Our Ref: BR/12/22/NMA

**Section 96A of the Town & Country Planning Act 1990 (as amended)
Town and Country Planning (Development Management Procedure) (England) Order 2015
(as amended) - Article 10**

Non material amendment following the grant of BR/213/21/HH to include small reduction of the proposed depth of the balconies deck to ensure there will be no protrusion or significant visual difference between the proposed balconied at No.12 & 14 and the existing at No.16 & 18, alter proposed windows to be in keeping with the existing sash windows at No.12 and carry out the division of window panes through coherently with the doors and Upgraded wooden sash windows.

14 The Steyne Bognor Regis PO21 1TP

TITLE: Proposed Plans and Elevations

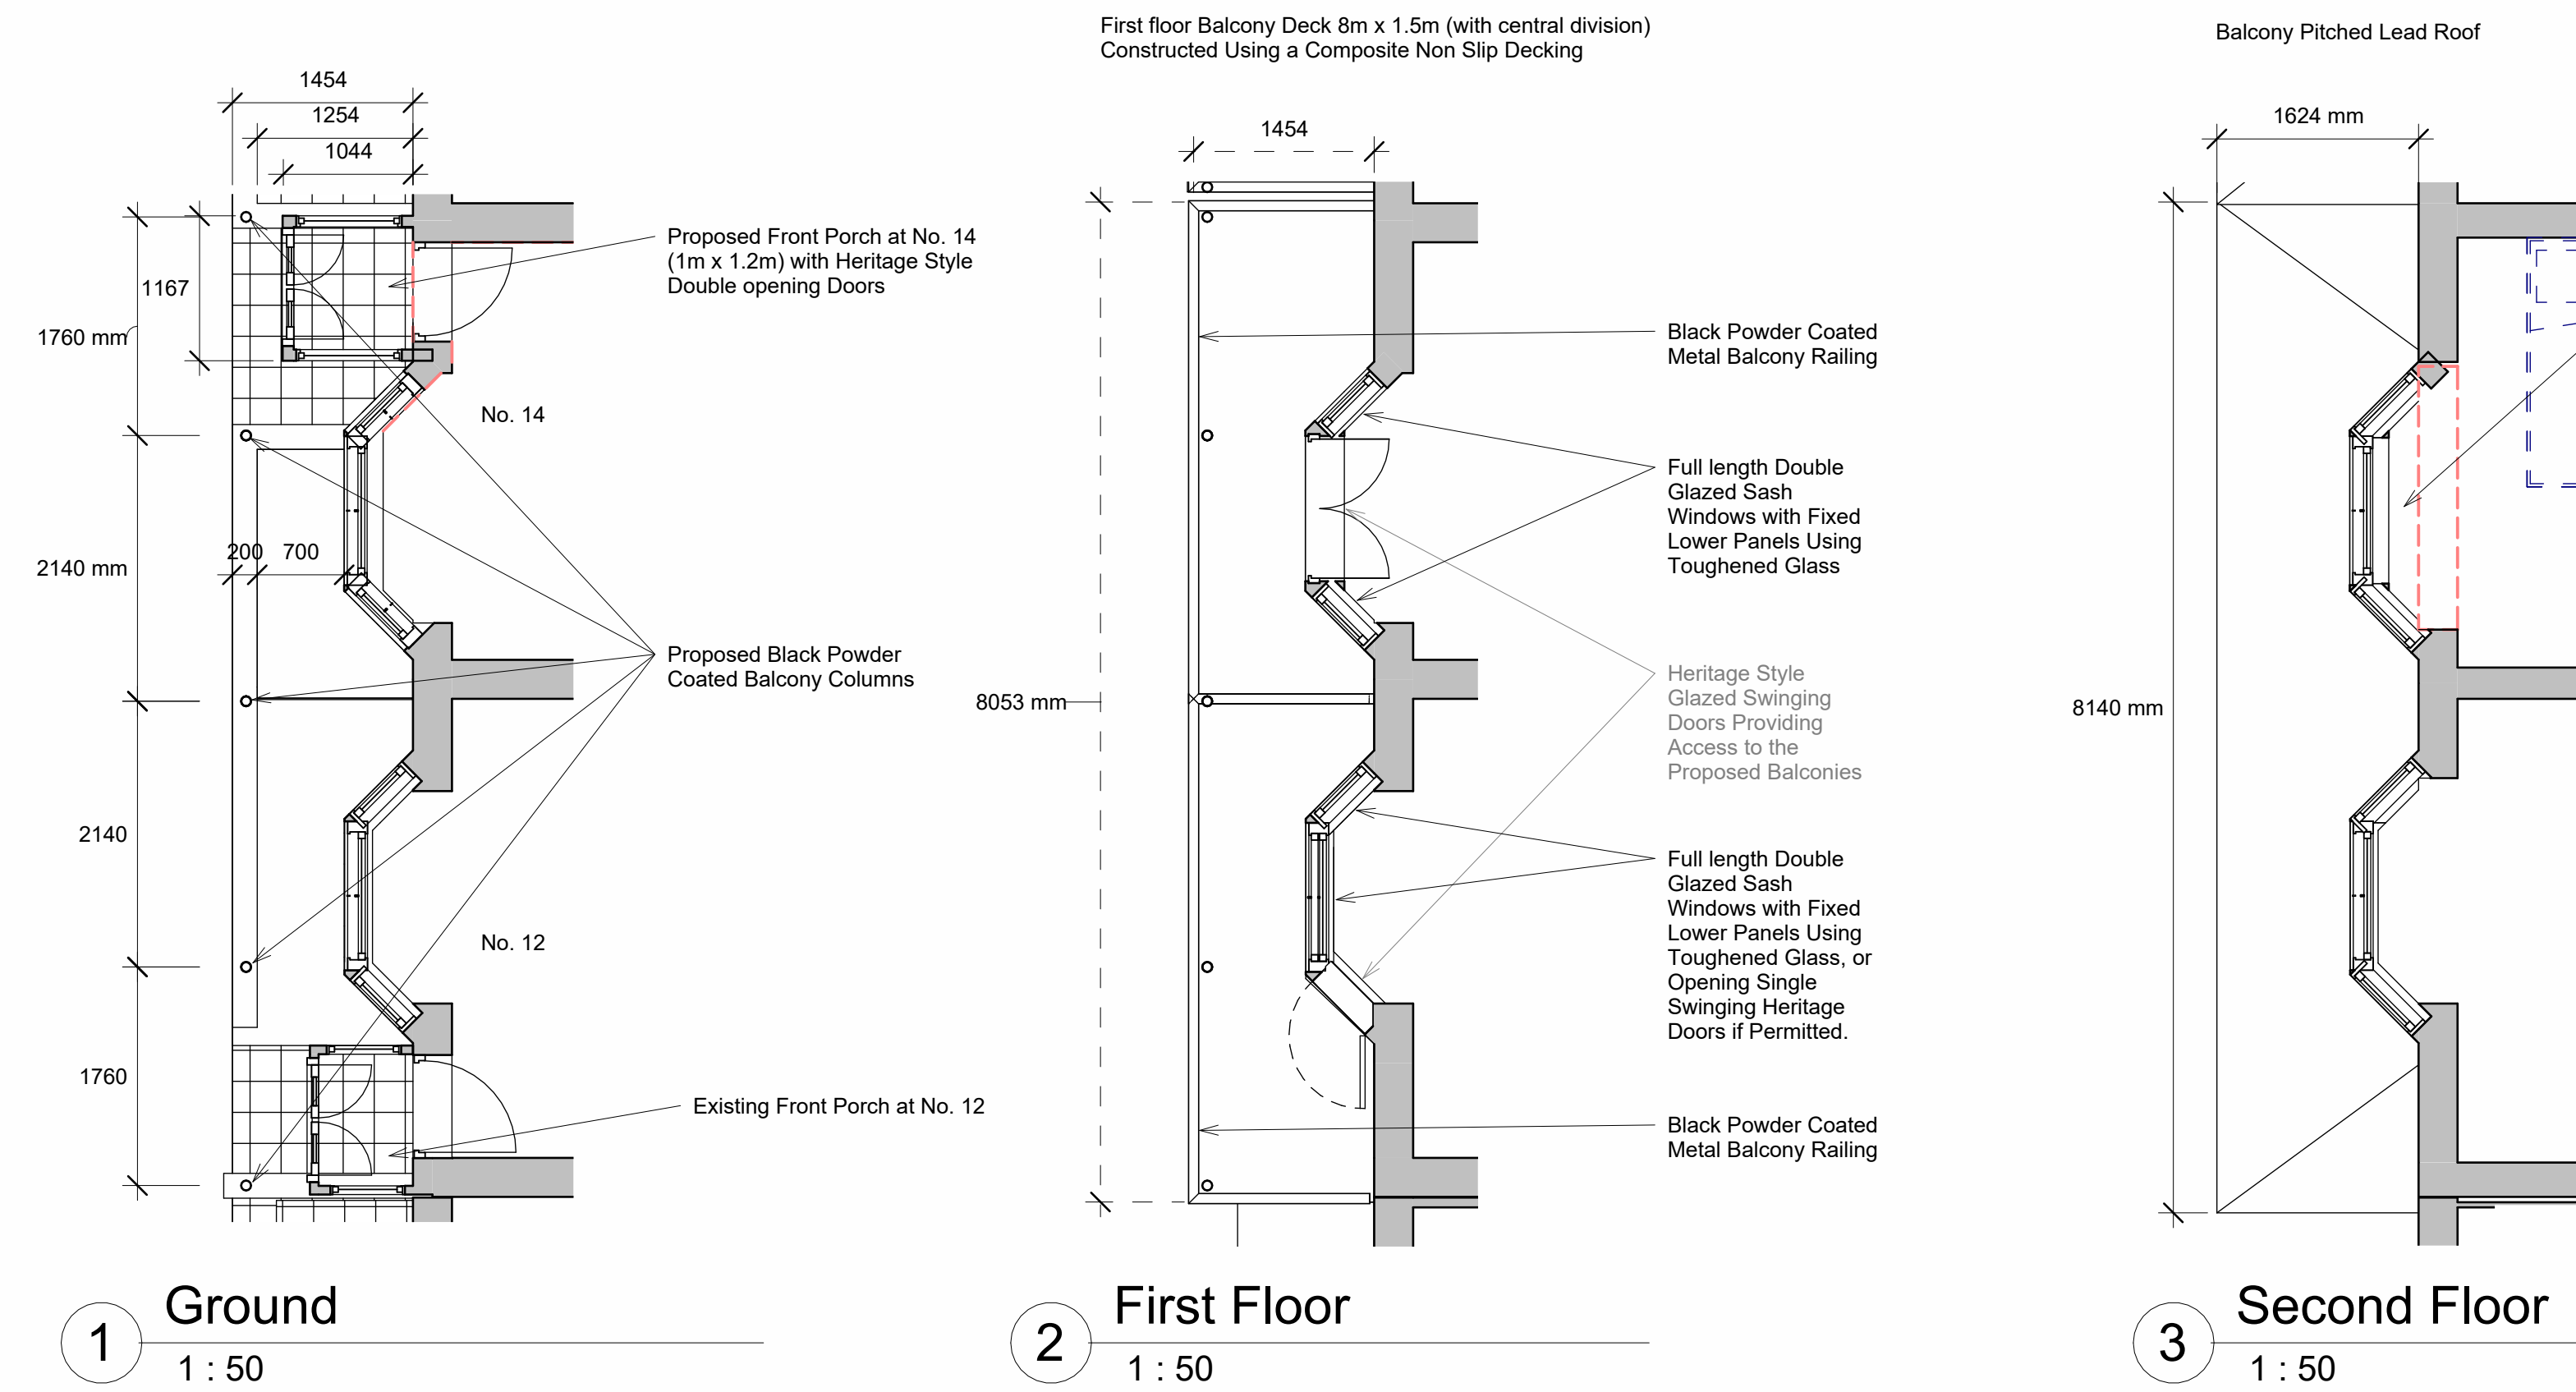
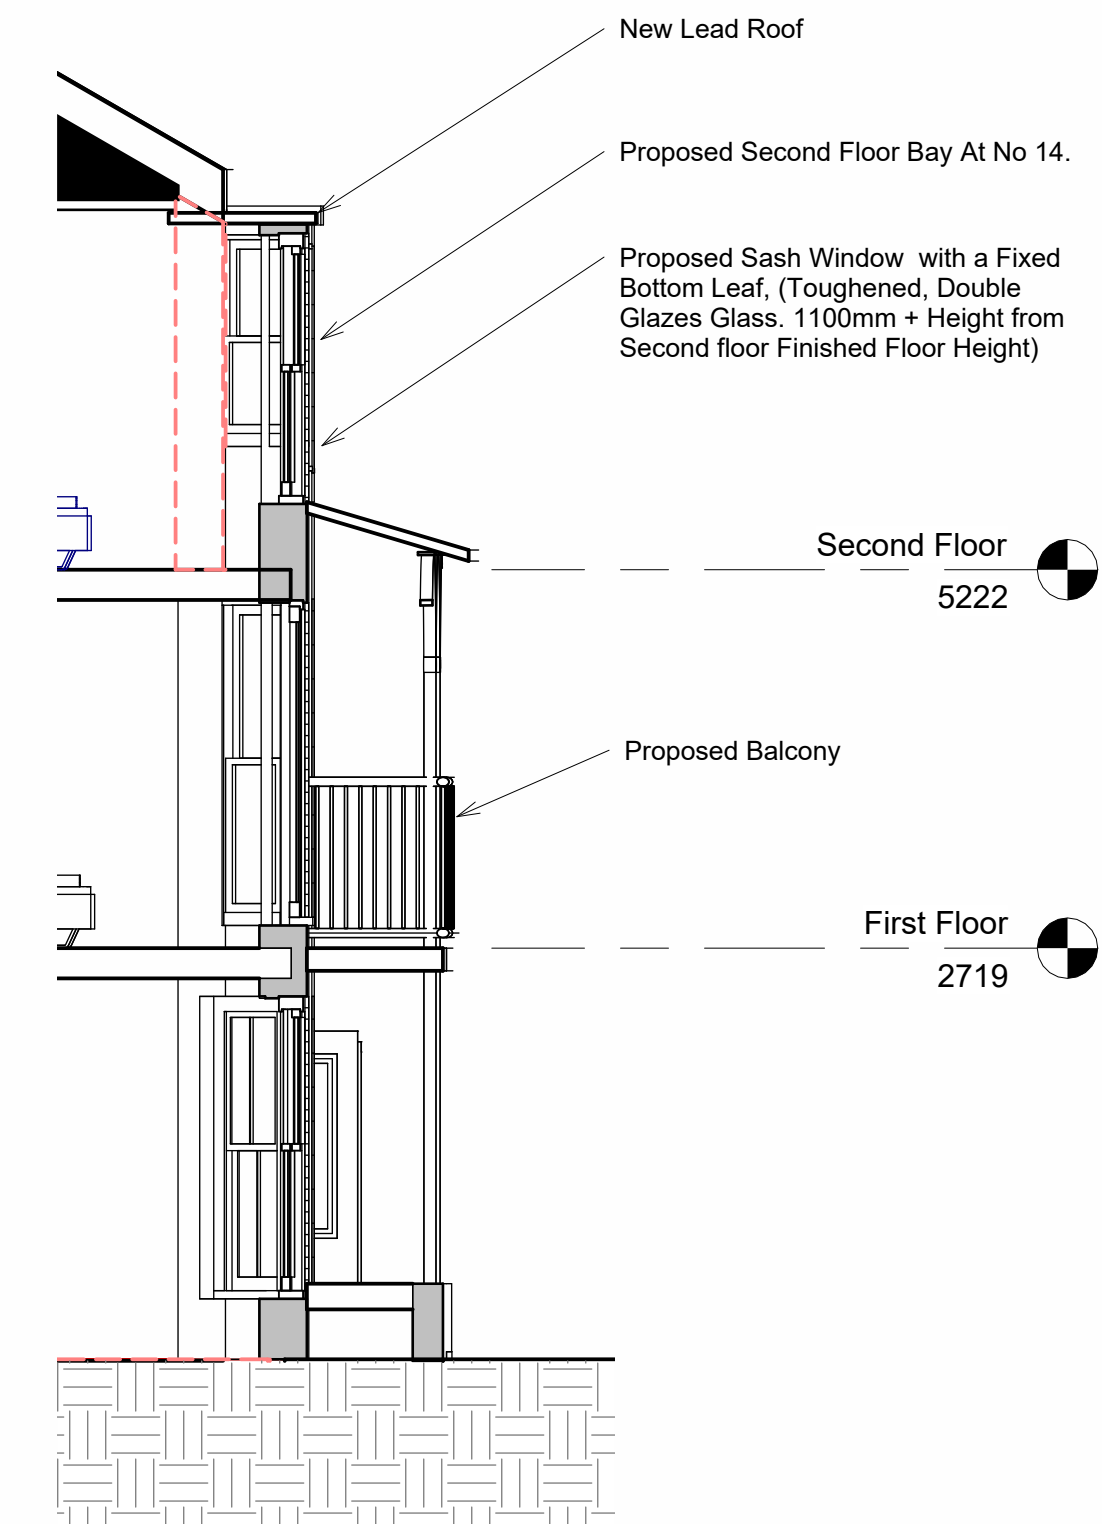
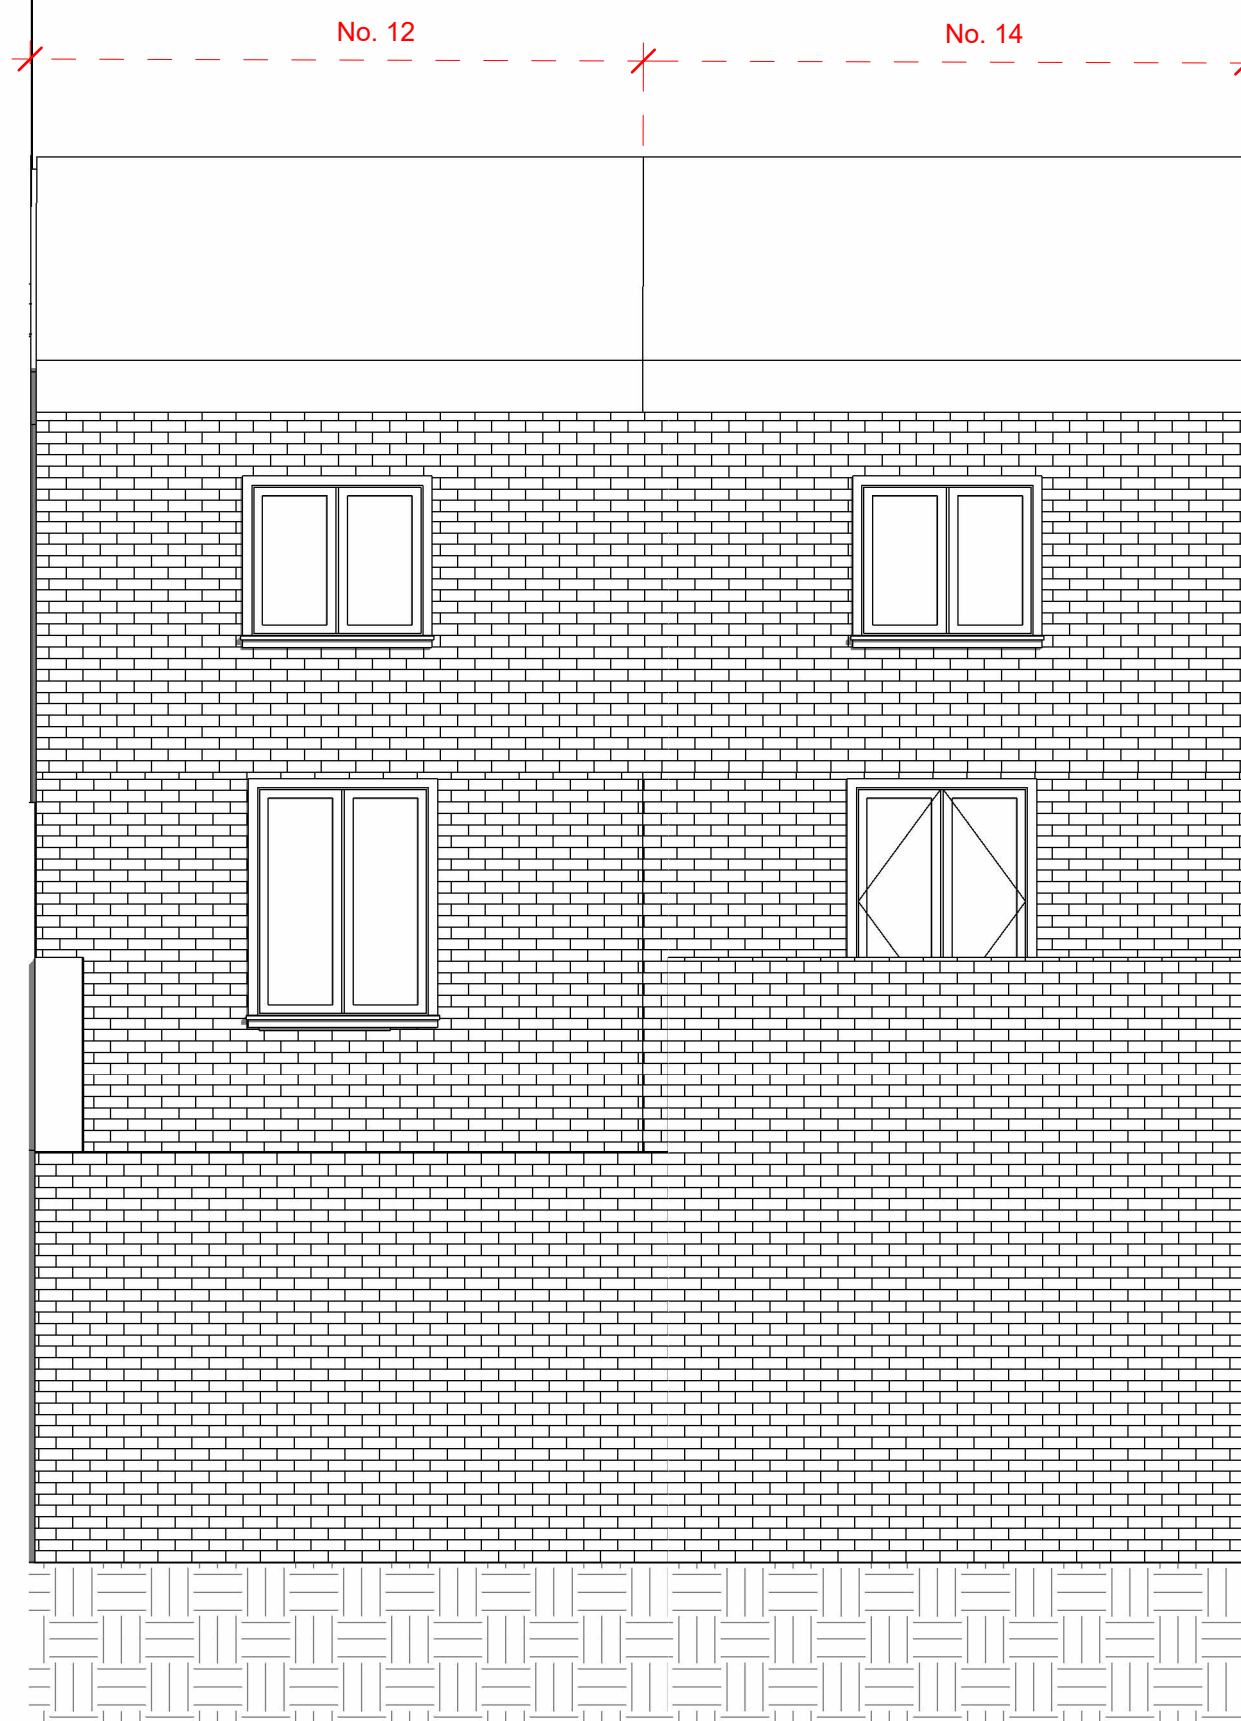
- A reduction to the depth of the balcony. This will alter from 1.5m to 1.4m and is minor in nature.
- The windows will also be sliding sash to match neighbouring properties.
